Our Case Number: ABP-311468-21

Re: Proposed Riverine Pedestrian and Cycle Bridge at Station Road, Lifford, Co. Donegal
115m in length between Lifford Co. Donegal and Strabane, Co. Tyrone

Our Ref: 177AE Riverine DNG

Referral under Section 51(3)(b) of the Roads Act, 1993 and under Section 226 and Section 177AE of the Planning and Development Act, 2000, (As Amended):

GENERAL EMBANKMENT WIDENING DETAIL AT BRIDGE ABUTMENT
Scale 1:50

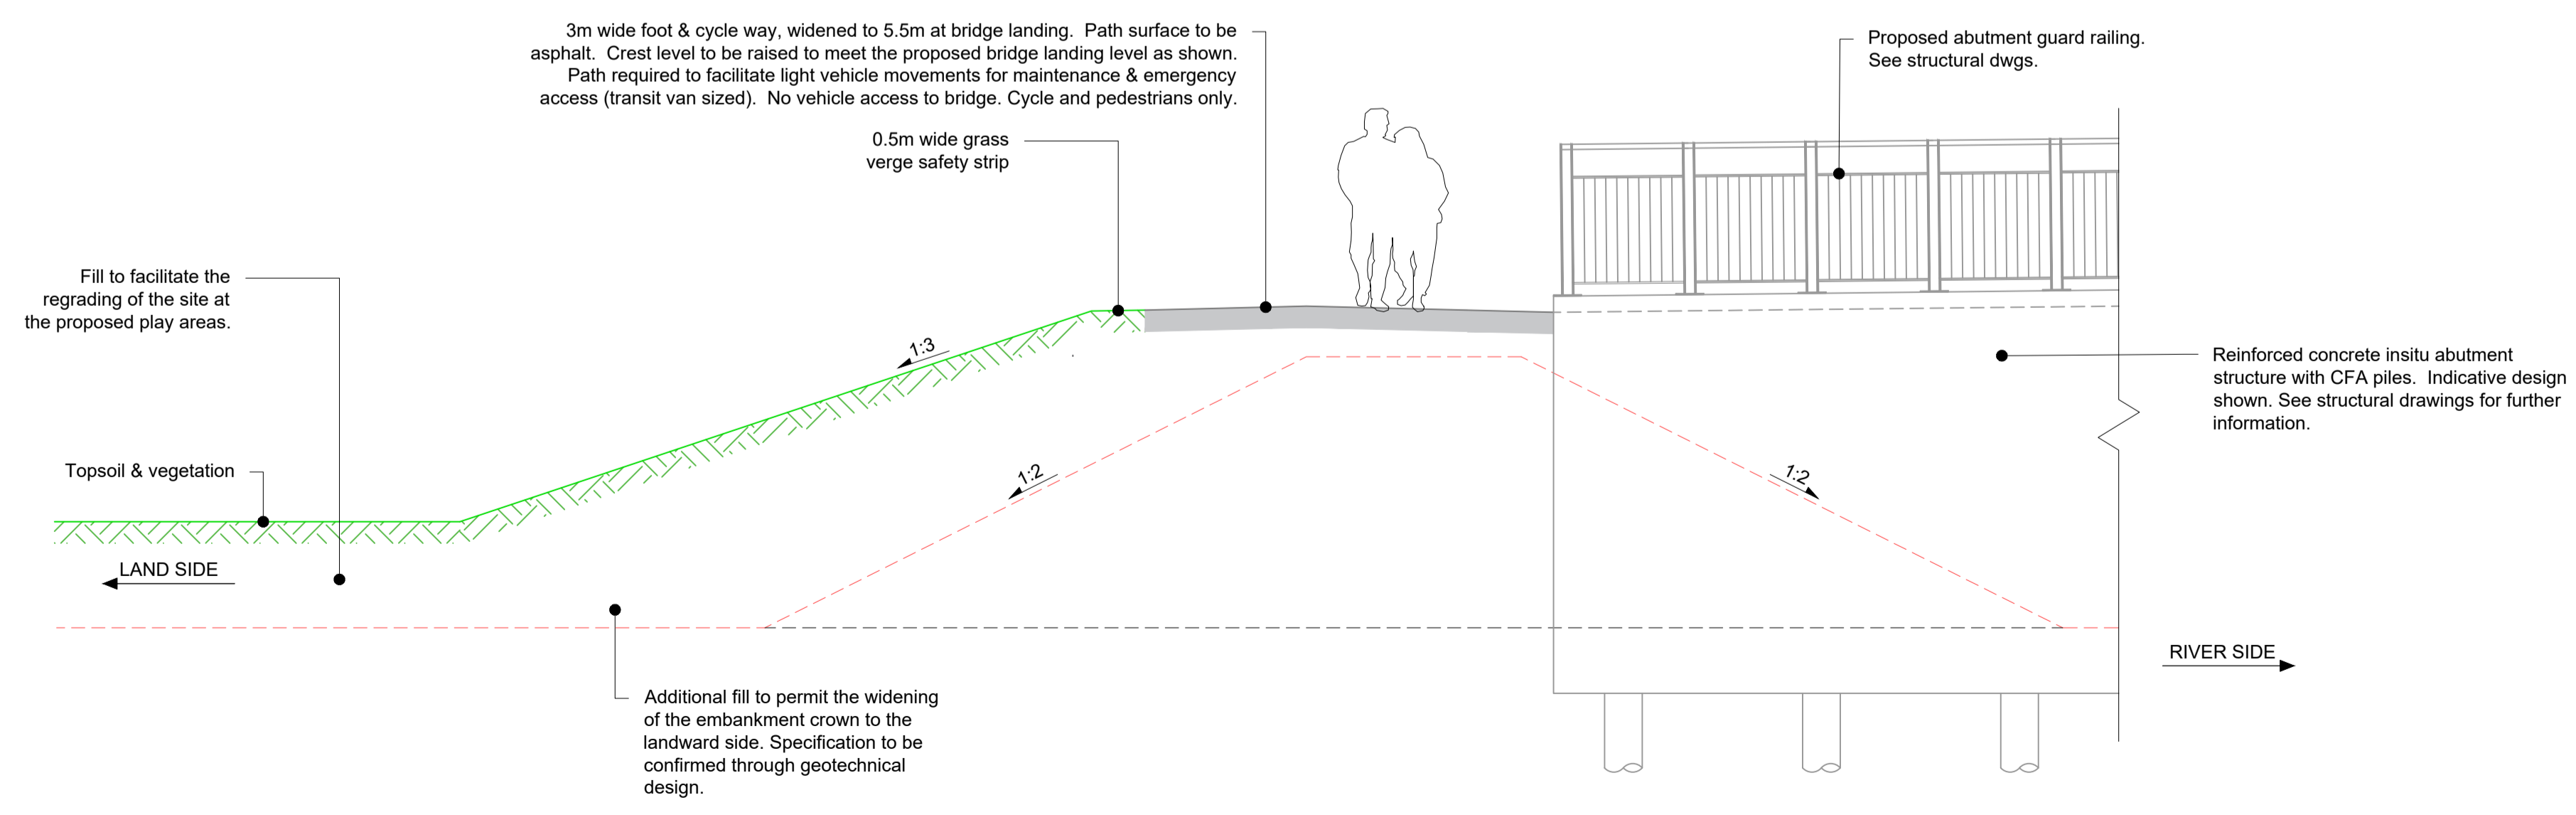
2. As a component of the mitigation proposed, archaeological test excavations, undertaken by an archaeologist licenced under Section 26 of the National Monuments (Amendment) Act 1930-2104, shall be undertaken at the proposed locations of the western bridge abutments and other areas where ground disturbances are proposed. Test excavations are to be undertaken in compliance with a method statement submitted with an archaeological excavation licence application and with the conditions of any licence issued and are to take place to the uppermost archaeological horizons only, where they survive. Where archaeological material is shown to be present, the archaeologist shall stop works in the affected area to facilitate evaluation and shall notify the NMS, who will advise further. Please note that all features/archaeological surfaces/objects within the test trenches are to be hand-cleaned and clearly visible for photographic purposes. Having completed the work, the archaeologist shall submit a written report to the Department of Housing, Local Government and Heritage outlining the results of the test-excavations. The report shall include a comprehensive Archaeological Impact Statement and shall comment on the degree, if any, to which the extent, location and levels of all proposed works required for the development will affect archaeological materials. This shall be illustrated with appropriate plans, sections, etc. The Archaeological Impact Statement shall also include proposals for further mitigatory measures, where necessary to protect the archaeological heritage. Where archaeological material, including objects and underwater cultural heritage, is shown to be present, further mitigatory measures may be recommended by this Department;
